From: Laura Gibbons
Sent: 20 August 2018 10:57
To: Planning.Responses
Cc: Anita Gardner
Subject: RE: Planning Consultation on: M/99/18/PL

Engineers Comments Regarding Surface Water Drainage
Please apply ENGD2B, ENGD4A, ENGD6A.

APPLICATION M/99/18/PL
NO:

Description of Works: 1 No. 2-bedroom dwelling

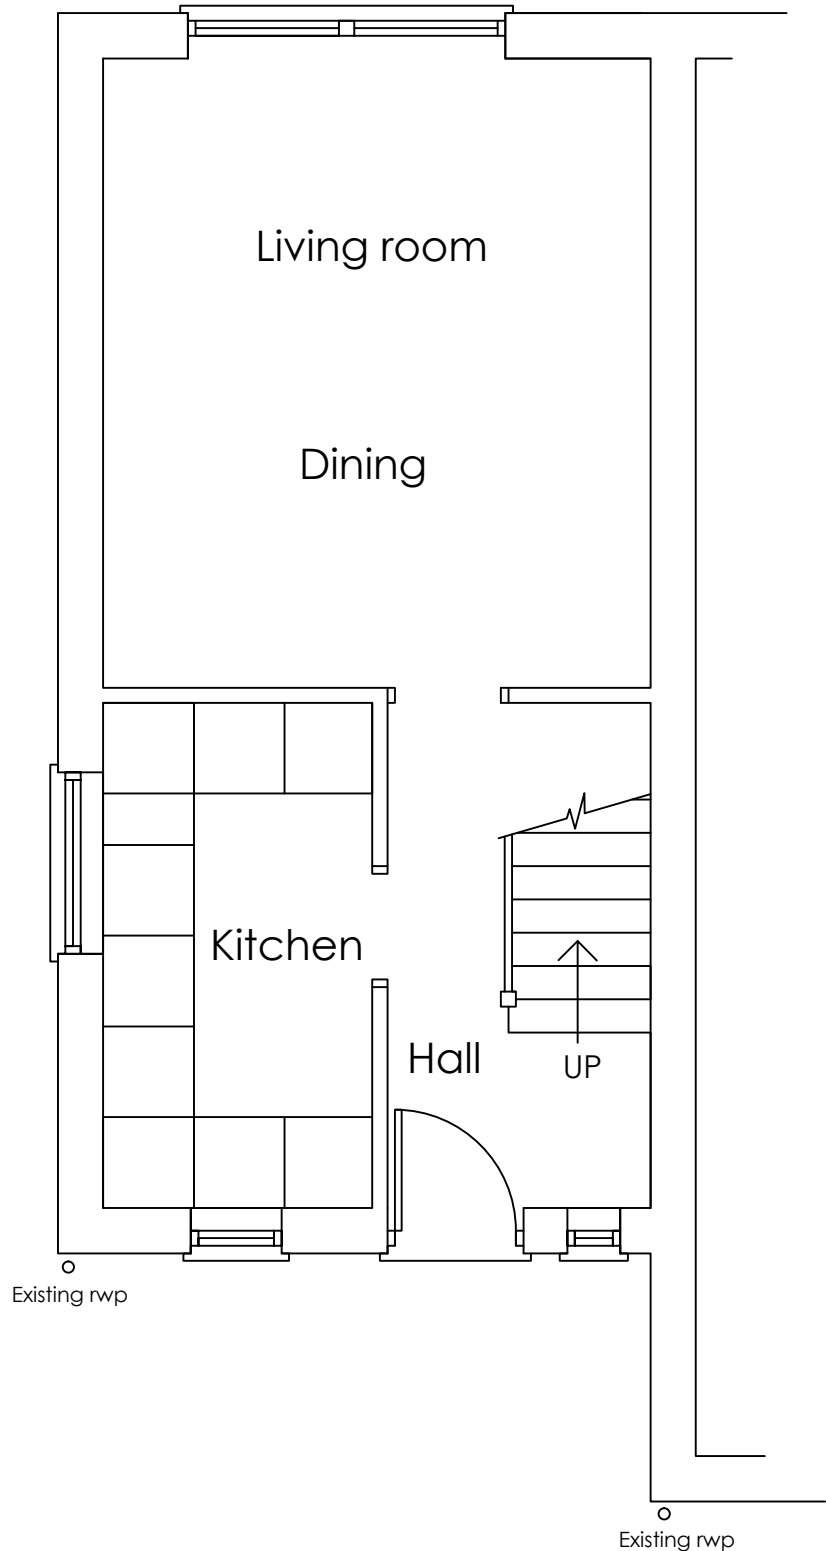
It should be noted there is a southern water foul sewer running to the rear of no. 14 and the proposed property. Our records also indicate a southern water surface water sewer runs to the rear of the properties. It is advised that the applicant contacts southern water as soon as possible to determine the exact position of this.
